**CITY OF PORTLAND, MAINE  
Portland Exposition Building Drainage Improvements  
Bid #5709**

**Current Date: March 11, 2009**

**NOTE: The following is a response to questions recently received on this bid:**

**C-01**

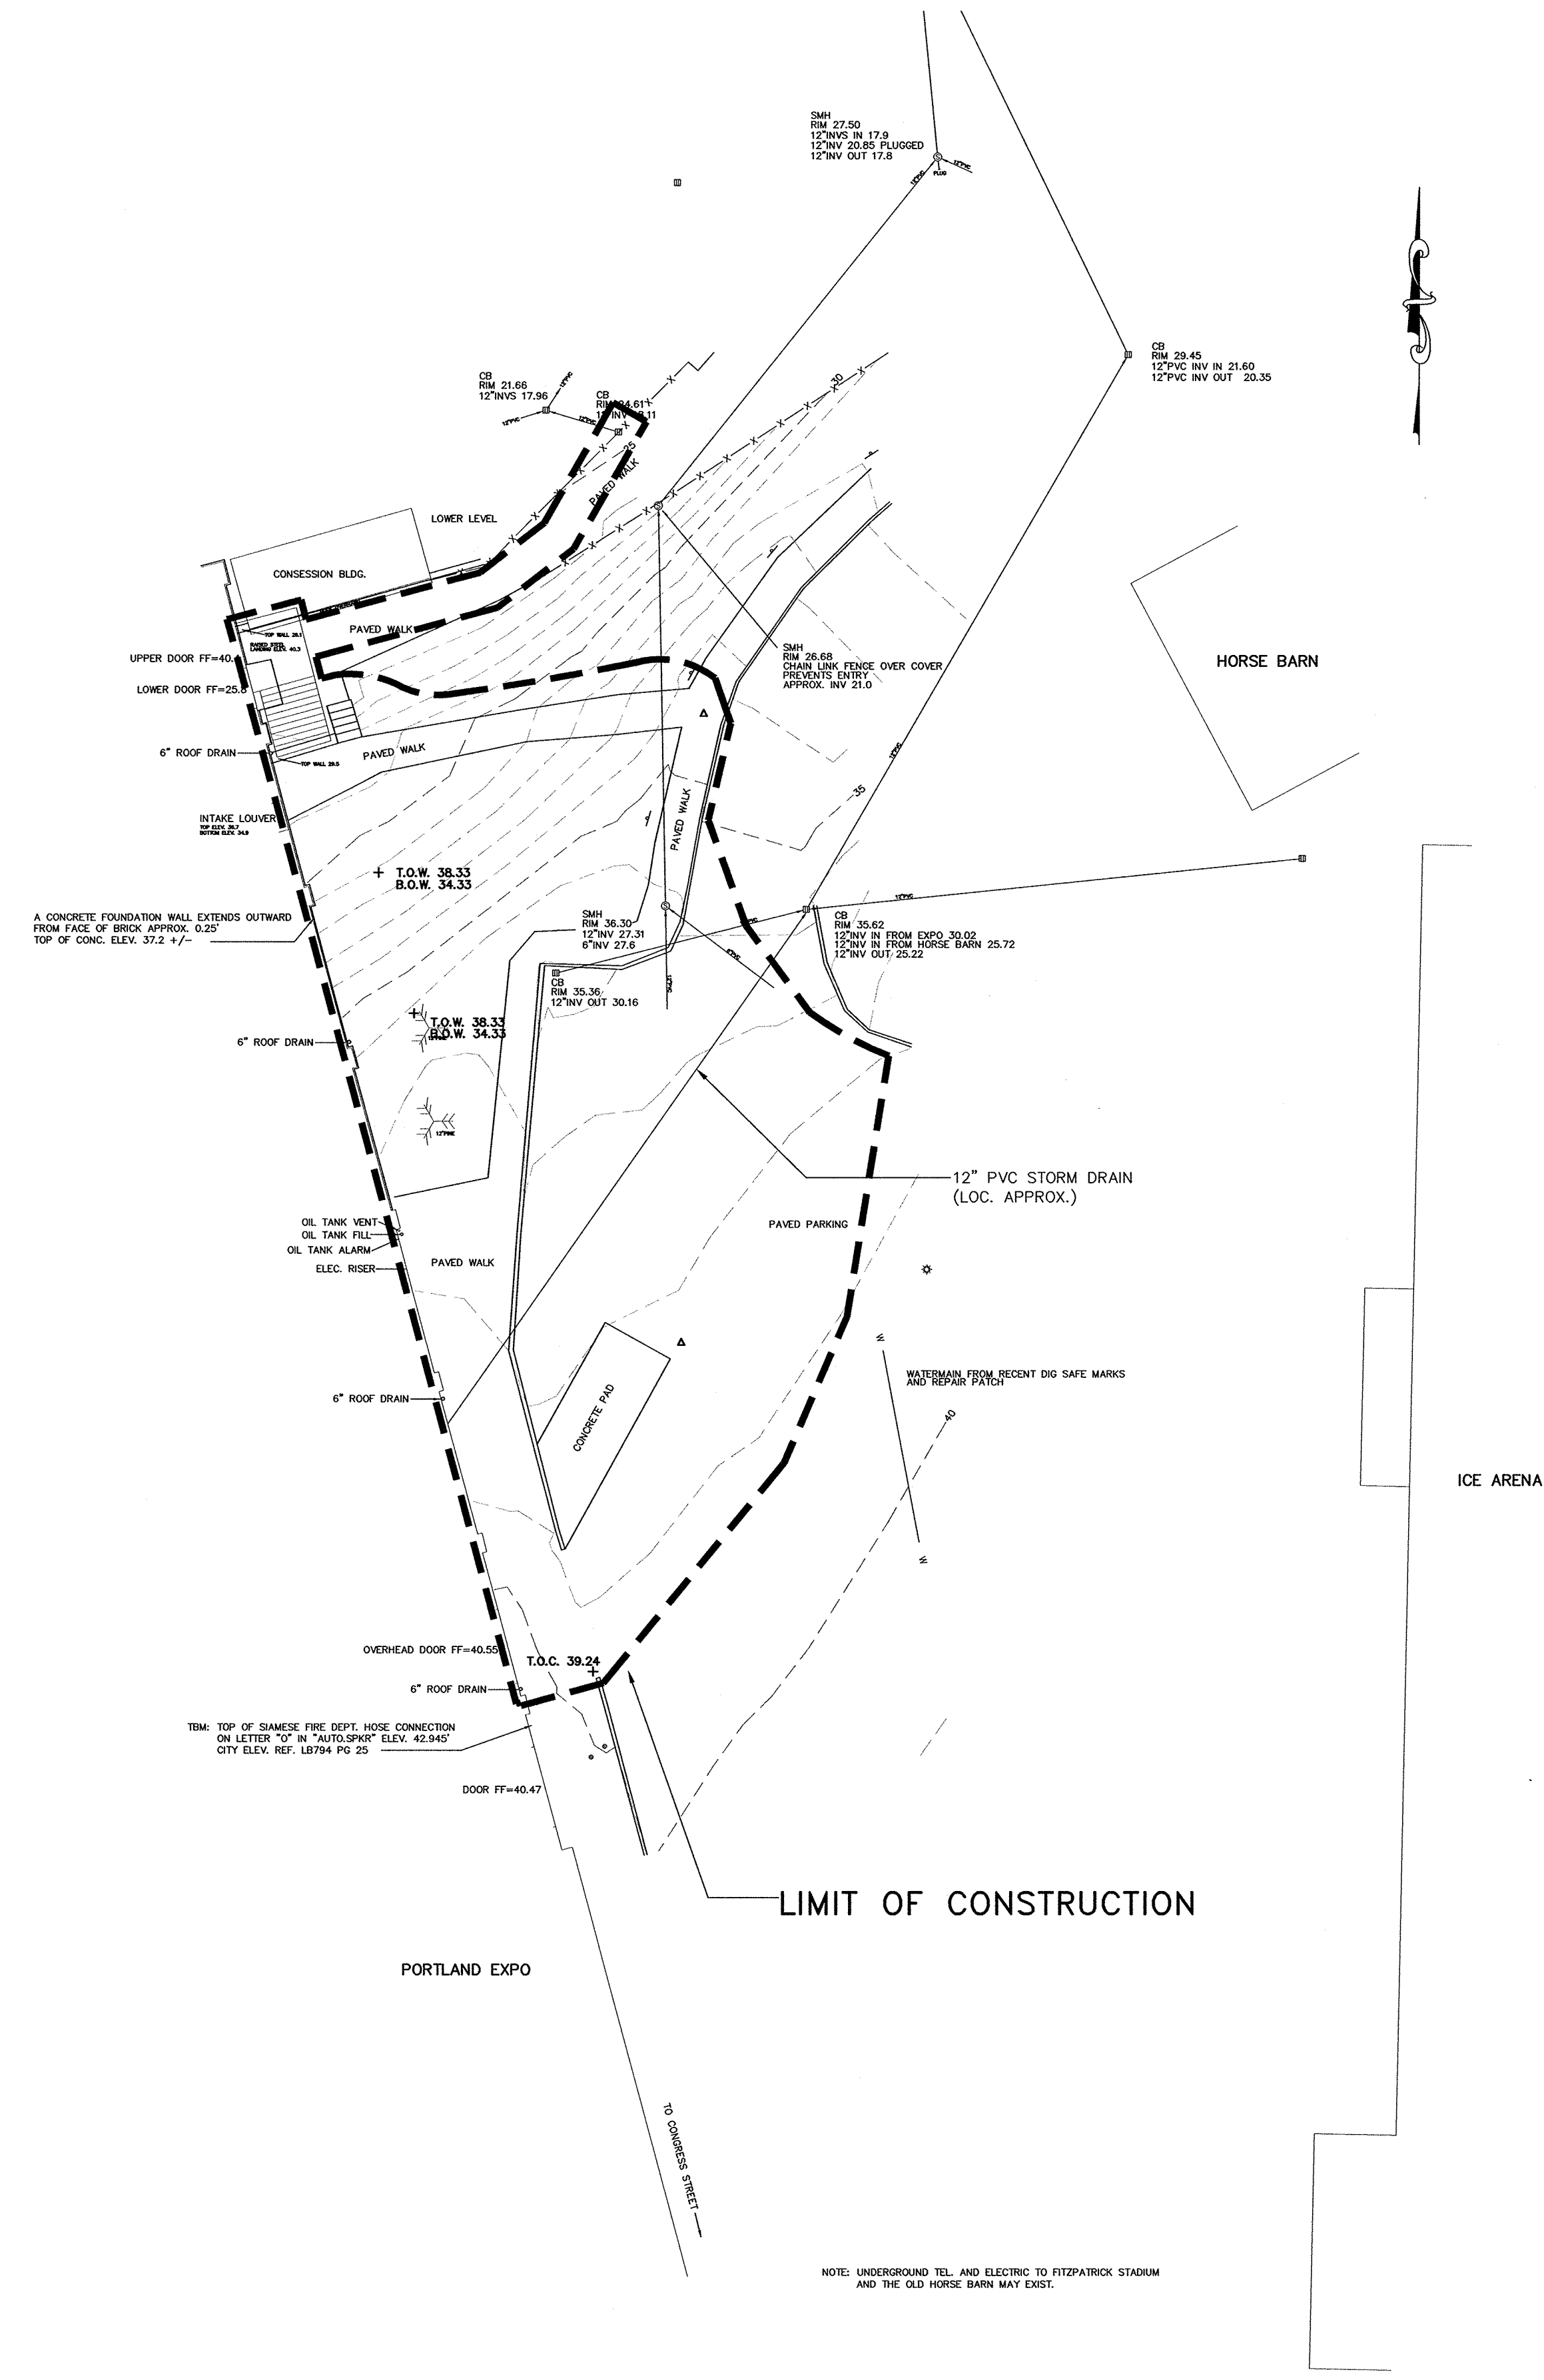
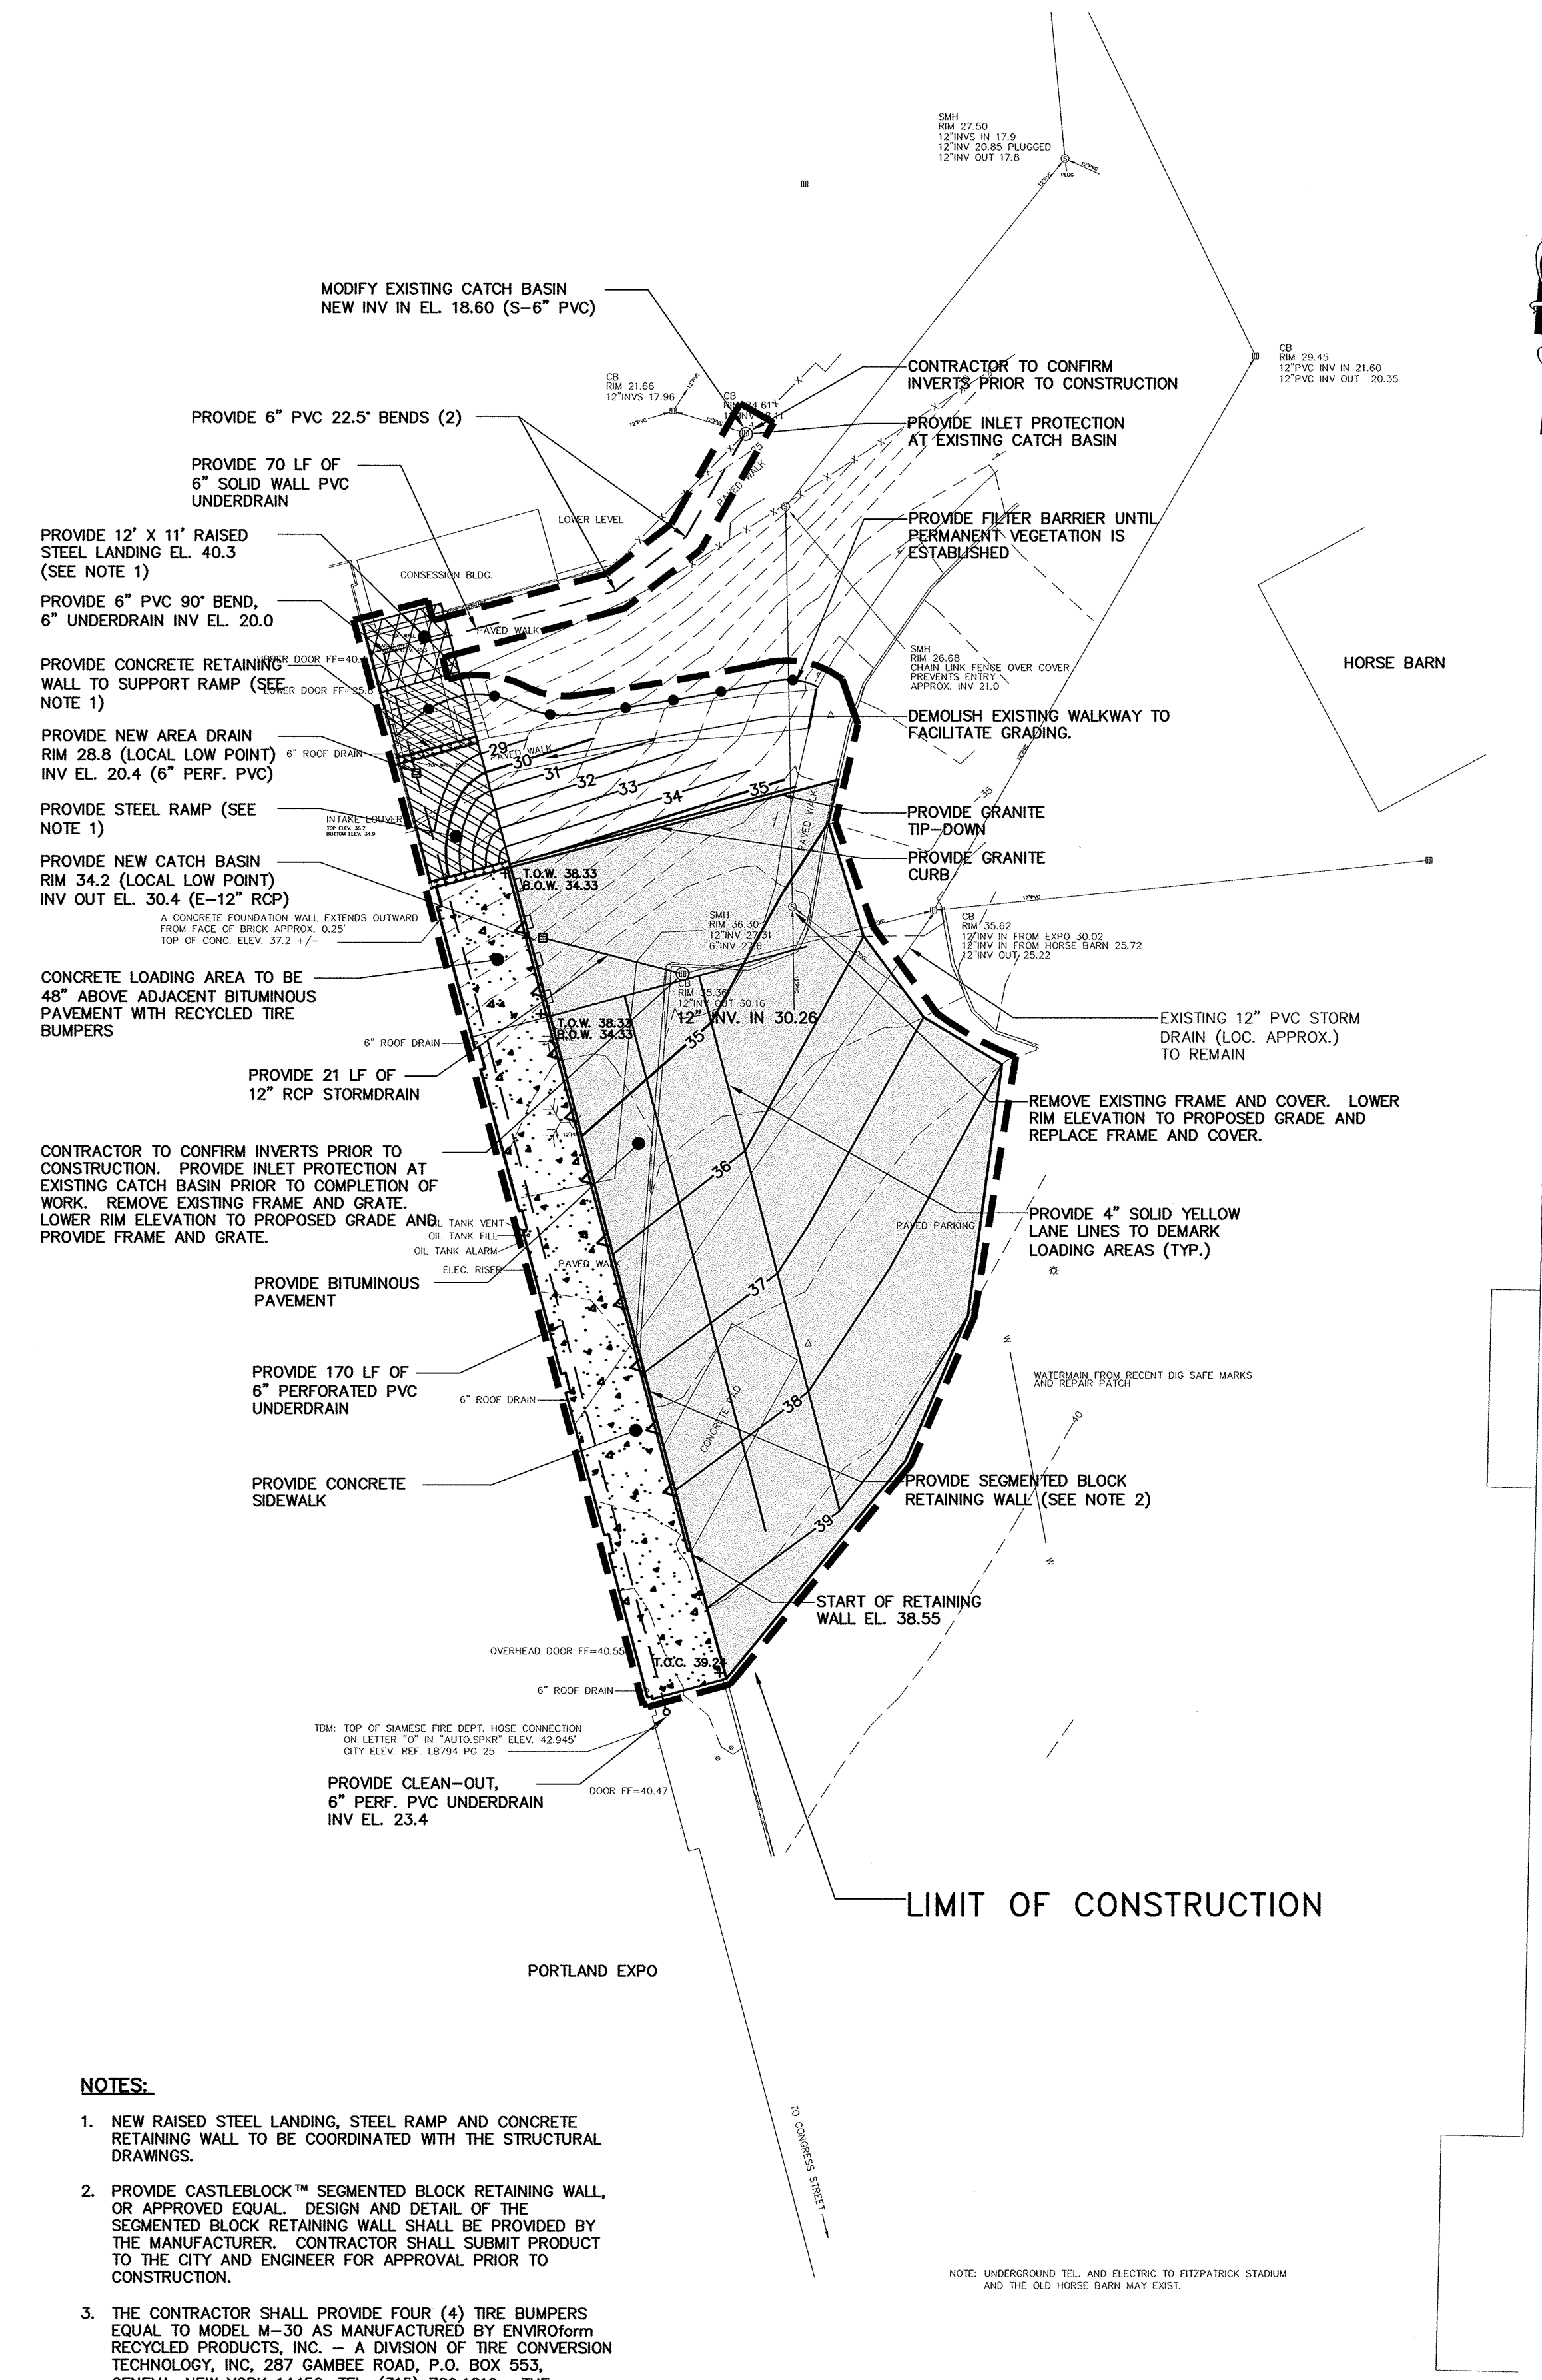
4. *Per Plan Sheet C-01 proposed site plan note "provide new area drain rim 28.8 (local low point) inv. El 20.4 (6" perf. PVC) – what type of structure is this - need construction detail if possible, or description?*

10. *Shall existing 6" roof drain as depicted on plan sheet C-01 be incorporated into proposed 6" underdrain system?*

11. *Will a detail for construction be provided for proposed "castleblock" segmented block retaining wall system?*

Sheet C-01: New Catch Basin shall be per attached Typical Catch Basin Detail, and in accordance with City of Portland Manhole and Catch Basin General Notes.

Sheet C-01: CONTRACTOR shall relocate the Oil Tank Fill, Oil Tank Vent, and Oil Tank Alarm in accordance with applicable codes and regulations, and as directed by City at no additional cost to the City.

Response 4) Area drain shall be Nyloplast by ADS 12" Inline Drain with 12" Standard H-20 Rated Grate with Riser and Tee , or approved equal. Inline Drain shall be installed in H-20 compliant manner as recommended by ADS, on and backfilled with a minimum of 12" of 3/4" crushed stone.

Response 10) Roof drains were previously re-routed by the City; the four (4) 6" roof drains as depicted on the plans are not in use, and were abandoned in place. In a manner acceptable to the City, CONTRACTOR shall coordinate with City and patch the Exposition building wall where pipes will be removed (by City).

Design and Detail shall be provided by the Manufacturer, see Note 2 on Sheet C-01. Design shall be stamped and signed by a Maine Licensed Professional Engineer.
